Subject: Short Plat Application SP-25-00002 Sageview

RE: 202500073; SP-25-00002

TO: All Staff
FROM: Public Works Plan Review Team
DATE: January 21, 2025
SUBJECT: SP-25-00002 Sageview

SAGEVIEW BLA/SHORT PLAT

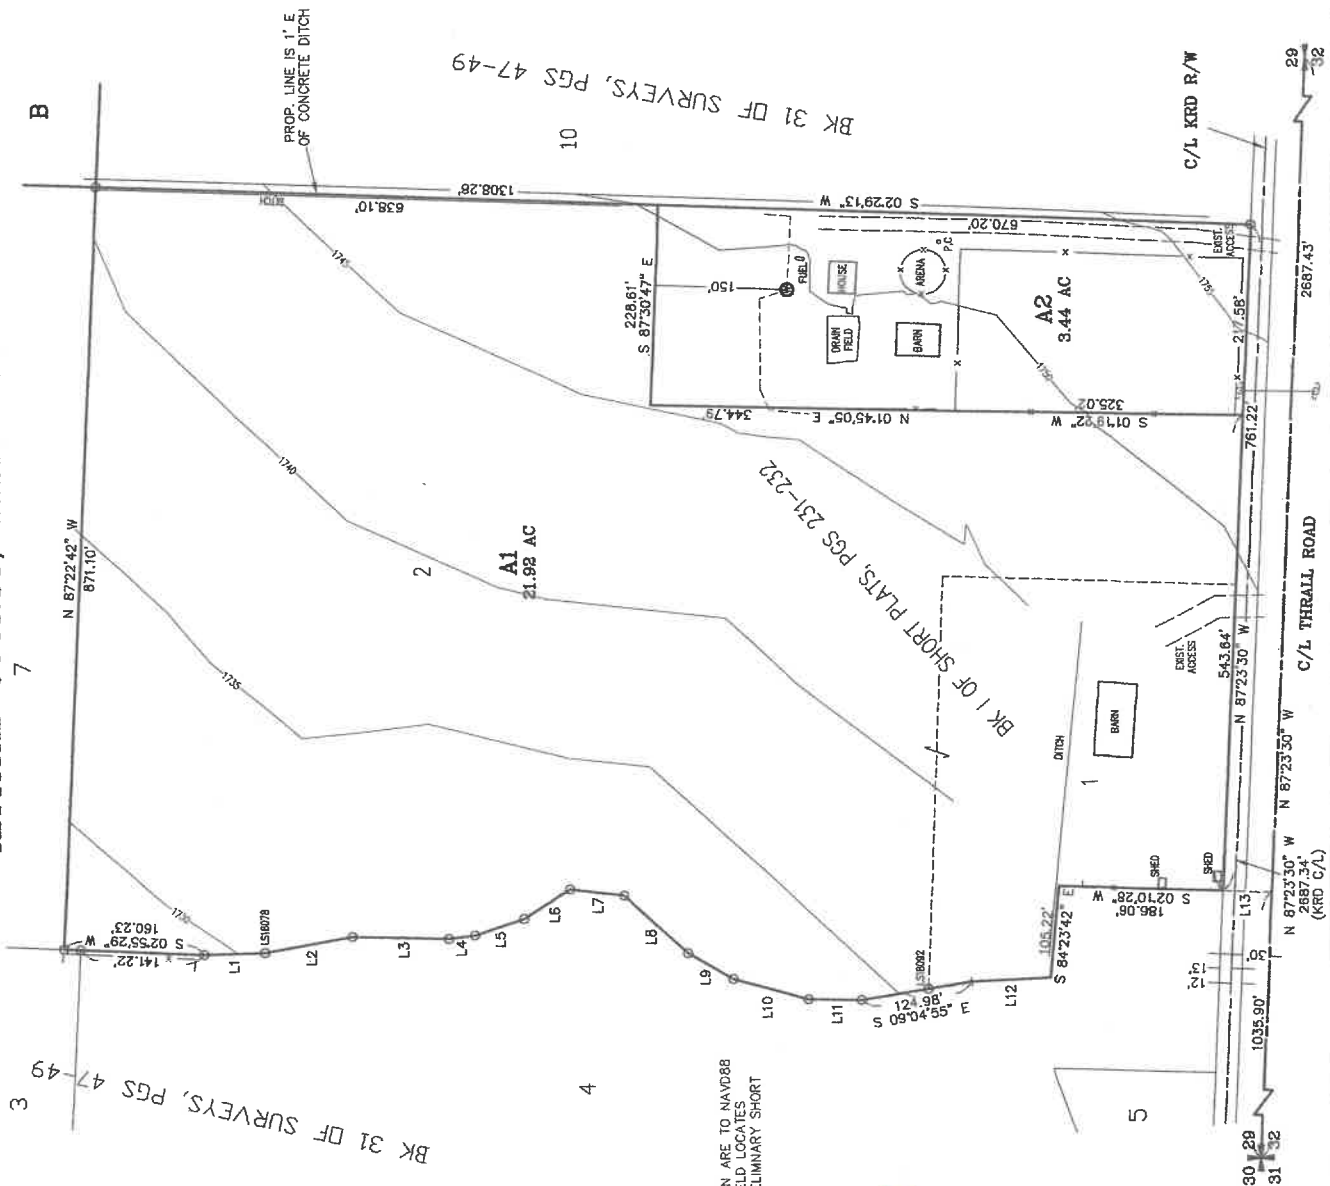
- The existing individual well on proposed lot A2 does not appear to meet the required 50-foot property line setback. If the existing well does not meet this setback requirement, the applicant may request an exemption from the current regulations.

<p>property will be viewed as being subject to short plat standards, and will be treated as such.</p> <ol style="list-style-type: none"> 4. Sheet 1 – Please clearly show a note similar to the following: “This sheet represents adjustment to boundary lines prior to Short Plat recorded simultaneously and shown on subsequent pages”. 5. Sheet 1 – Please show the following note (or something similar) on Lot A: “Lot A is a transitional parcel to be further subdivided on subsequent pages and should not be referenced as a legal lot after recording”. 6. Sheet 1 – Please identify previous and proposed boundaries. 7. Please set and show corners per Short Plat standards. 8. Sheet 2 – Elevation Datum note contains minor typo. 9. Please include a survey narrative explaining the BLA and simultaneous Short Platting. 10. Final document shall be filed as a short plat. All lots shall be referenced as being a portion of a short plat.
